Christina Stacey - Re: Permit #1787 - 41 Christy Rd

I am in the process of reviewing and approving your permit for front step replacement at the above-referenced address. Firstly, I wanted to apologize for the long delay in reviewing this permit. I appreciate your patience during this process.

Plot Plan

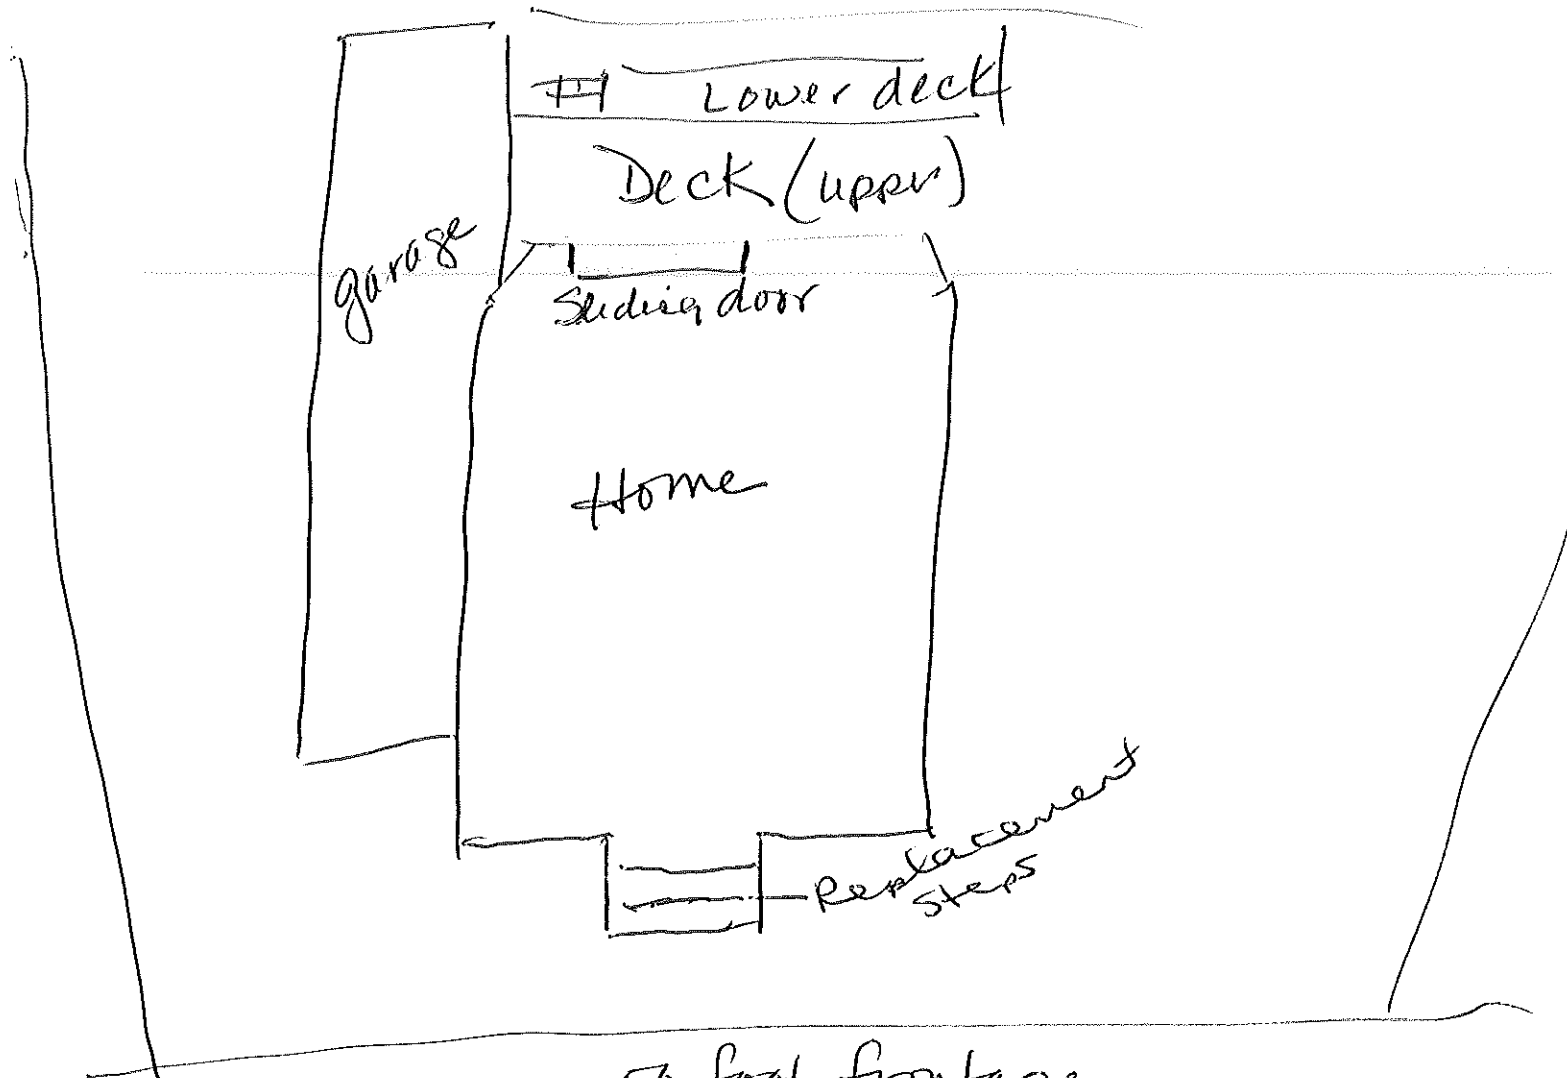
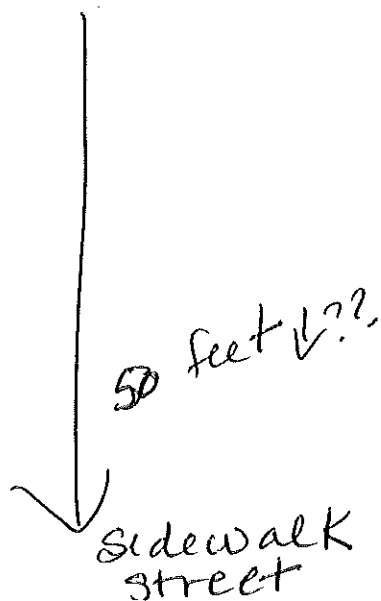
Before I sign off, I did have one quick question - can you just confirm that the replacement steps are the same footprint dimensions as the old ones? I assumed they were but there were no measurements included, so I wanted to double check.

Exact same measurements
